From: rob saunders <[REDACTED]>
Sent: 06 March 2019 11:59
To: Zac Denton
Cc: Jill Angel
Subject: Re: A/3/19/L - Weavers, High Street

FIRST FLOOR

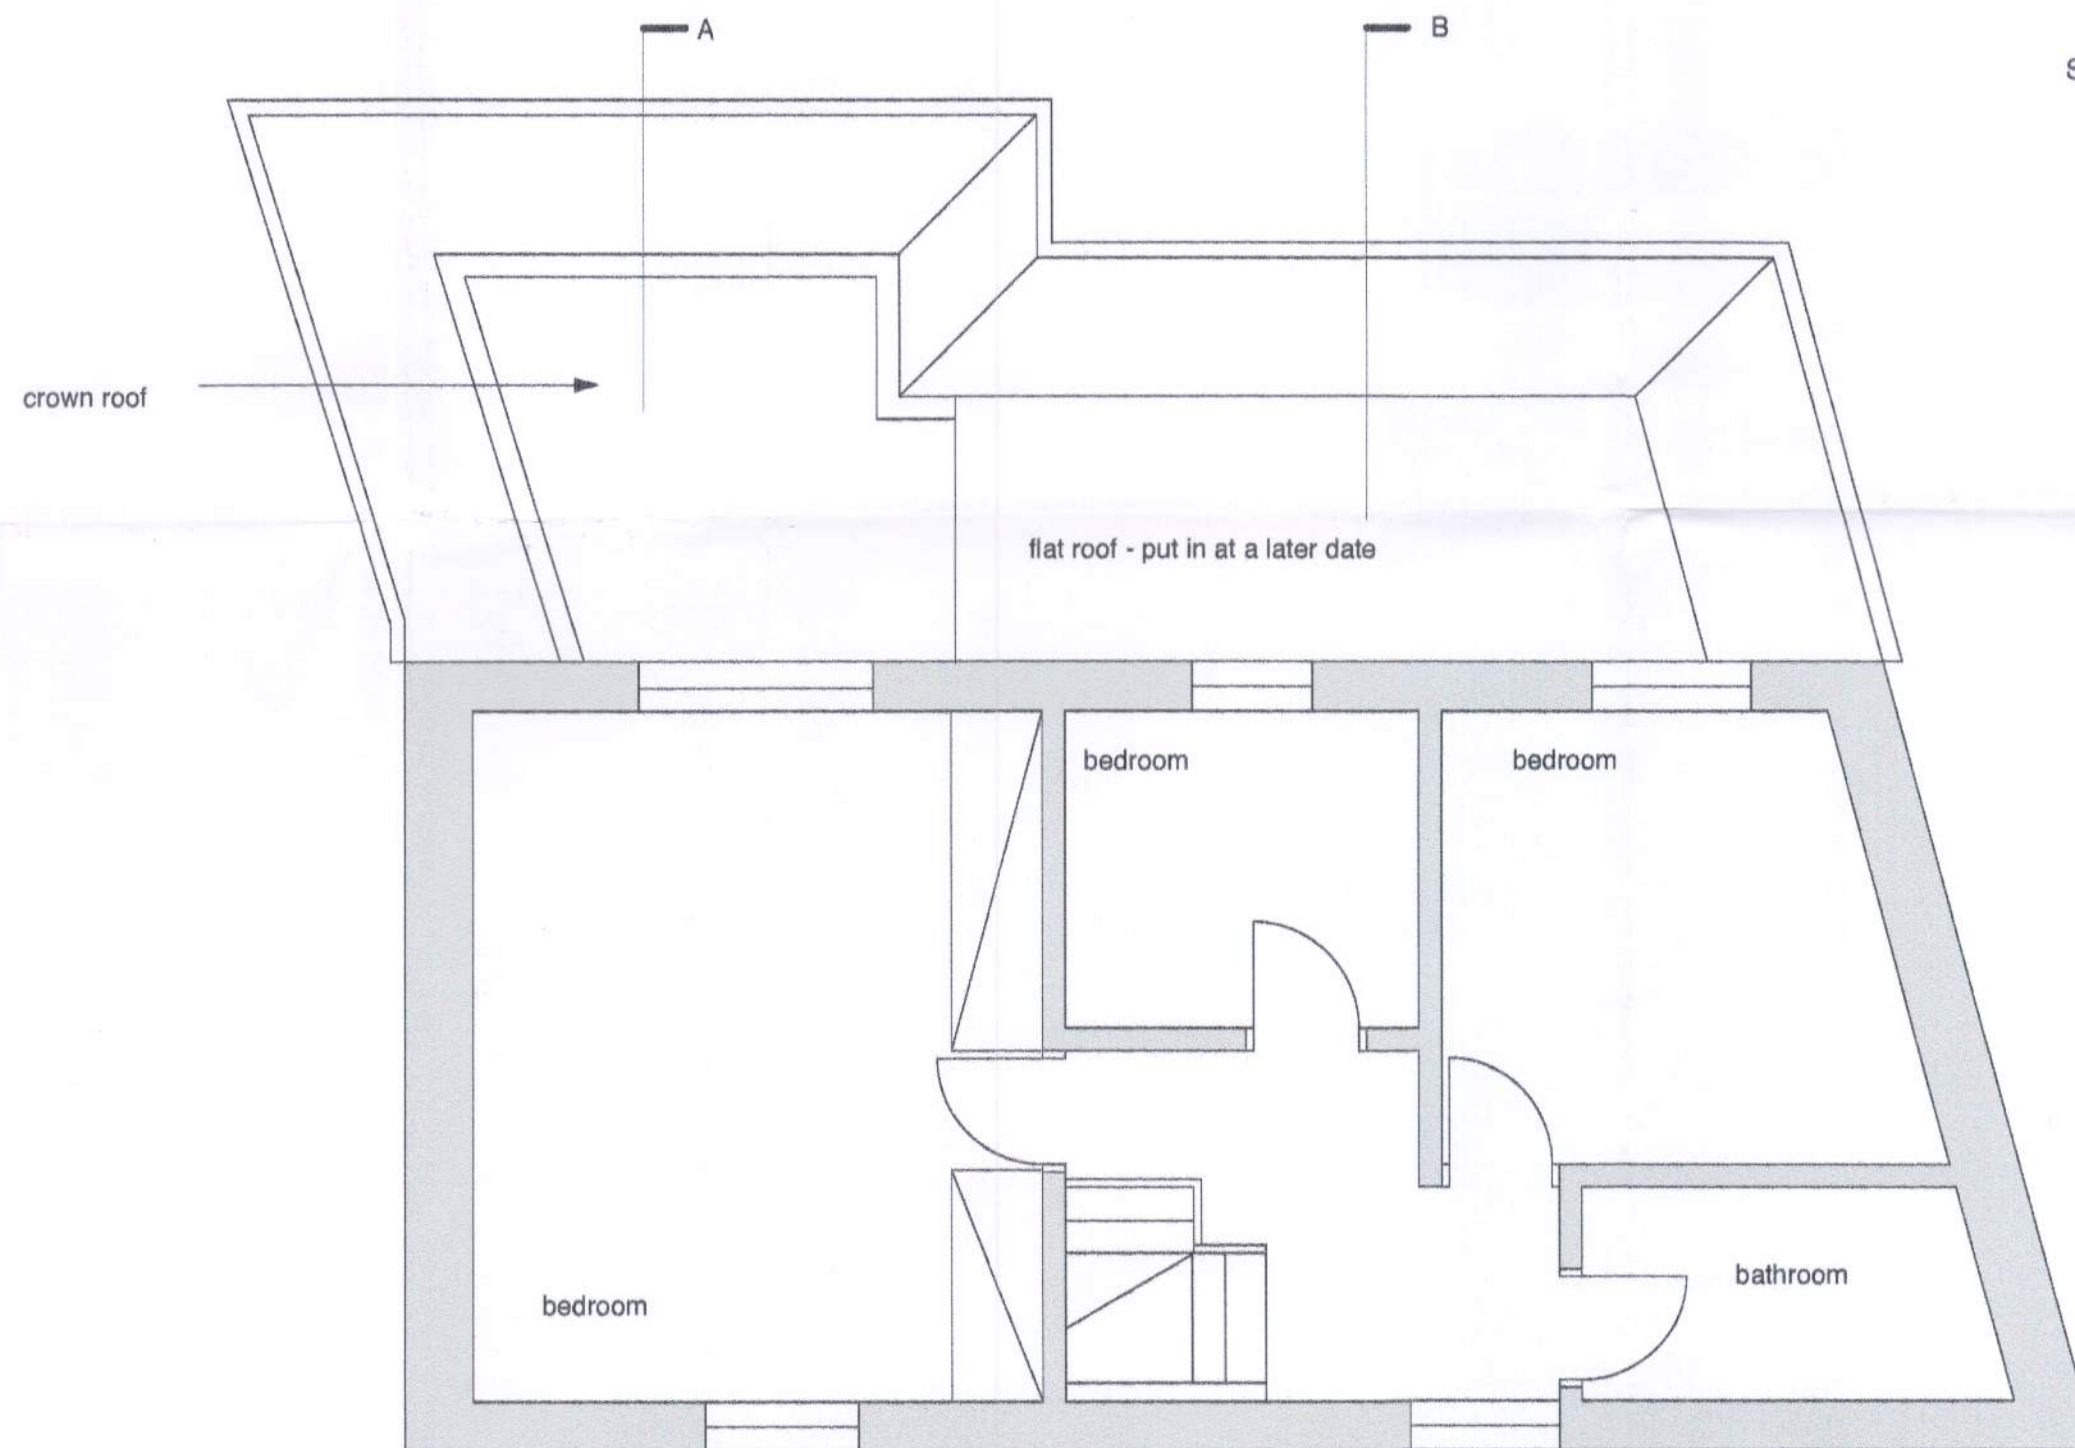
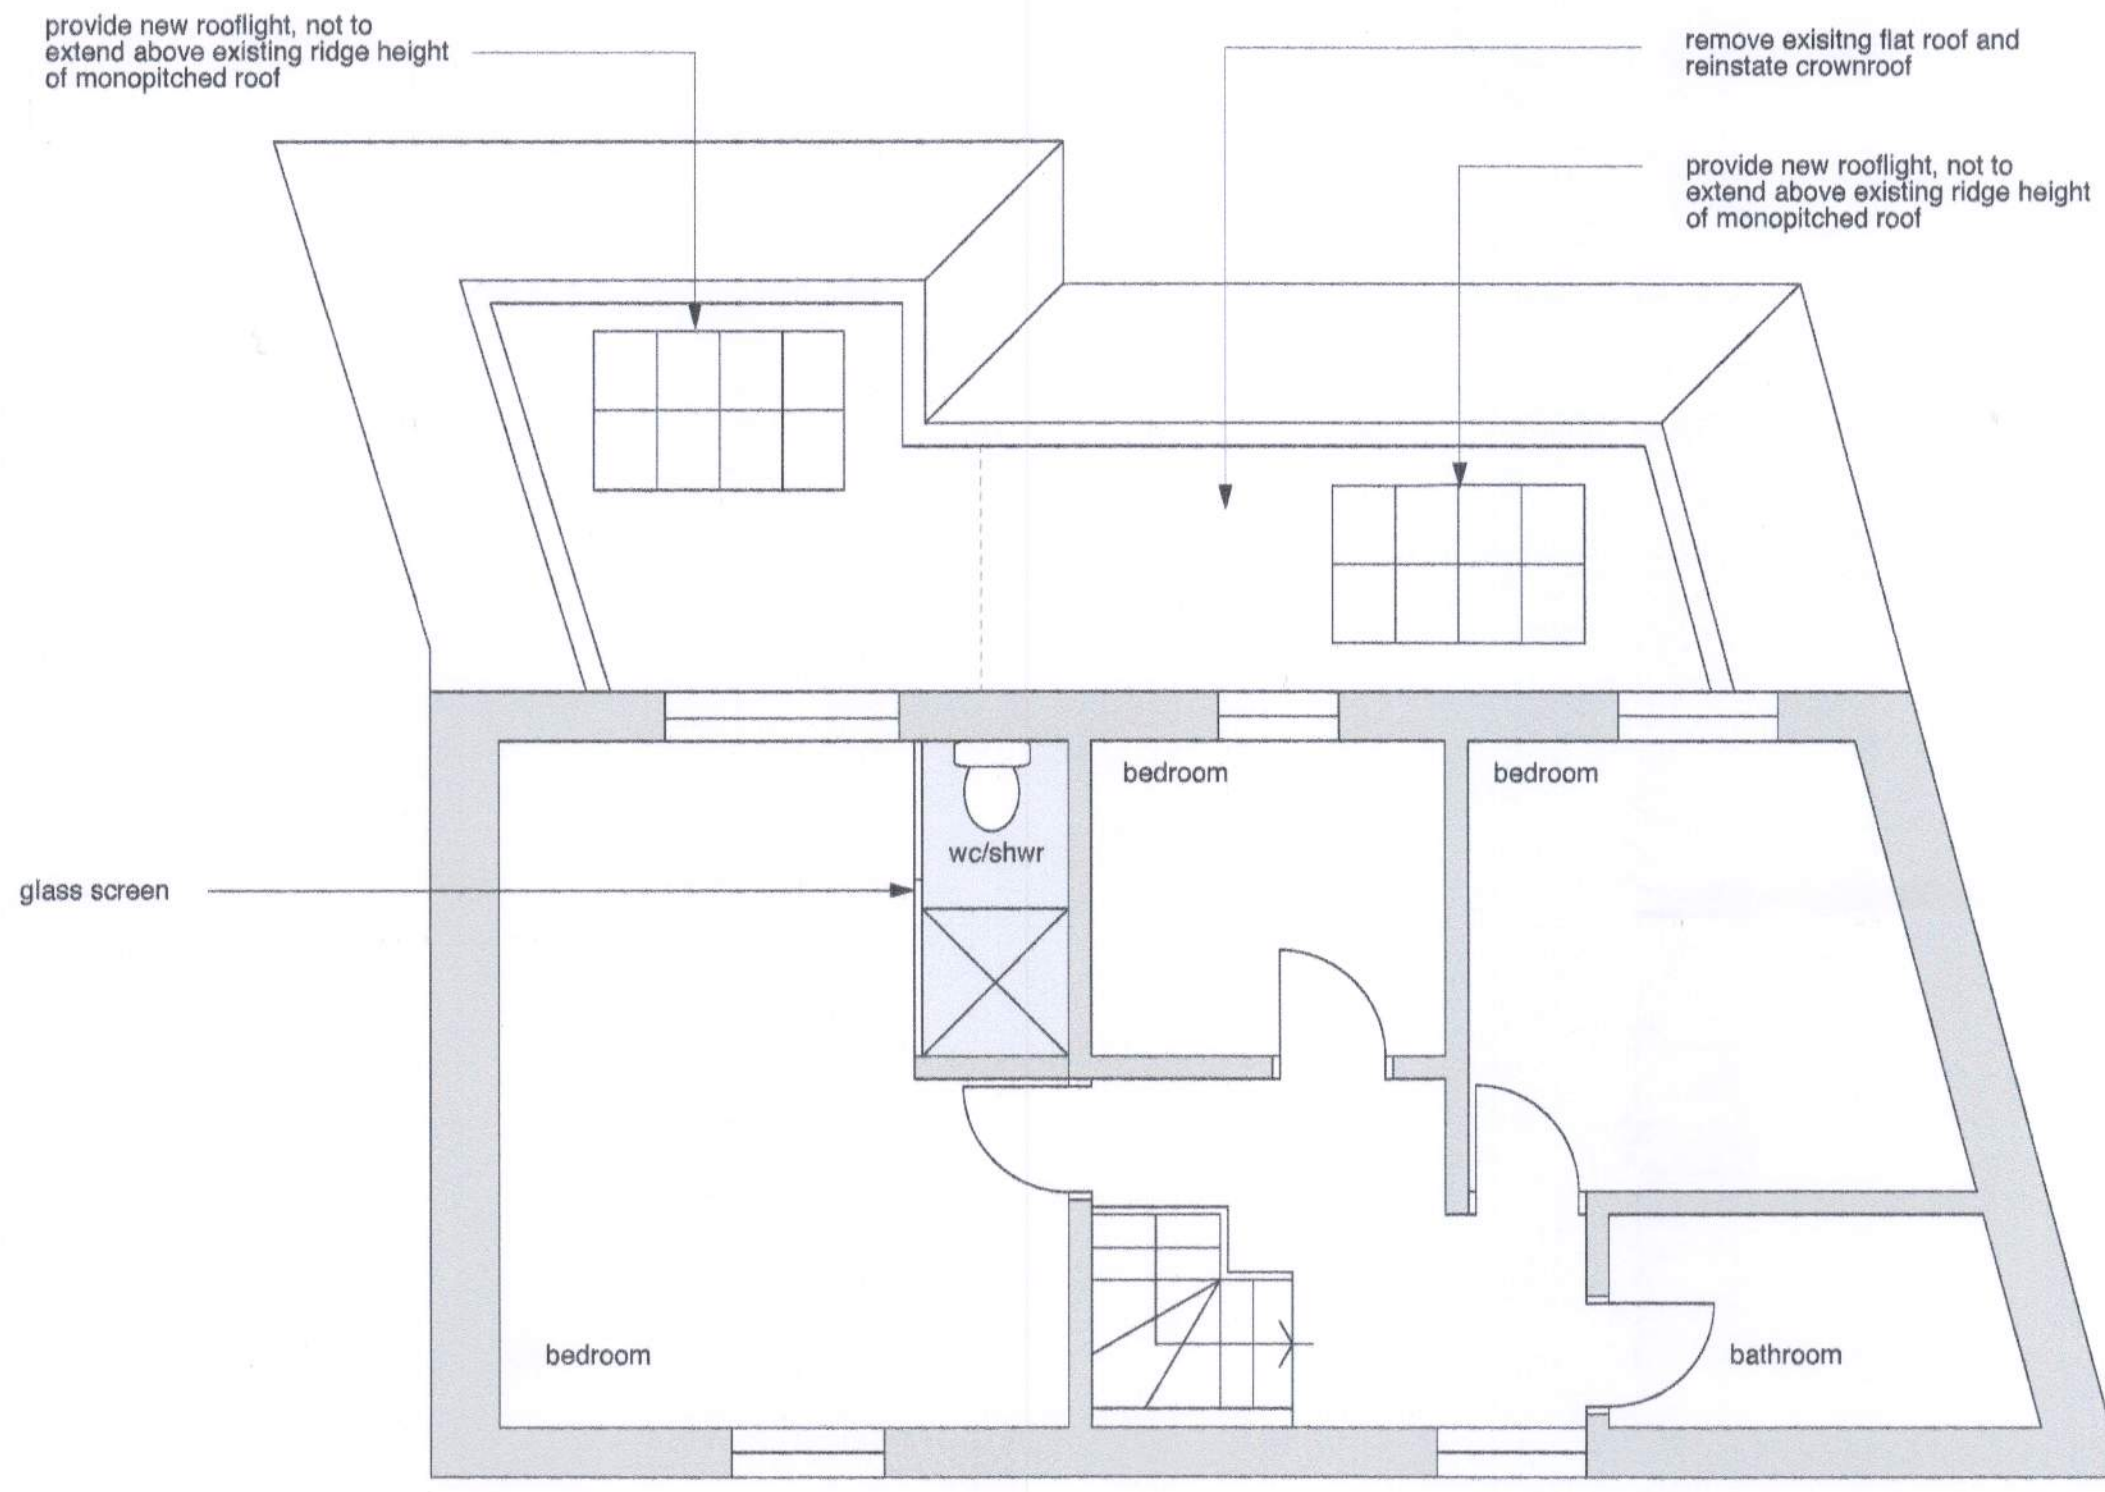
Do you have any further information? Relating to its physical appearance, size etc.?

Regarding the above application, do you have any details relating to the glass screen, proposed in the bathroom of the development? *E.g is it fully frames, glazed, what colour is it etc.*

I have provided further information on the glass screen and have put these on a drawing which has been posted to you today.

As can be seen the connections will be seamless so there will be very little disturbance of the original fabric and there are no demolition works except the removal of a wardrobe which of course is not original.

Yes the glazed panels will fit within a s/w timber frame which will be painted white.
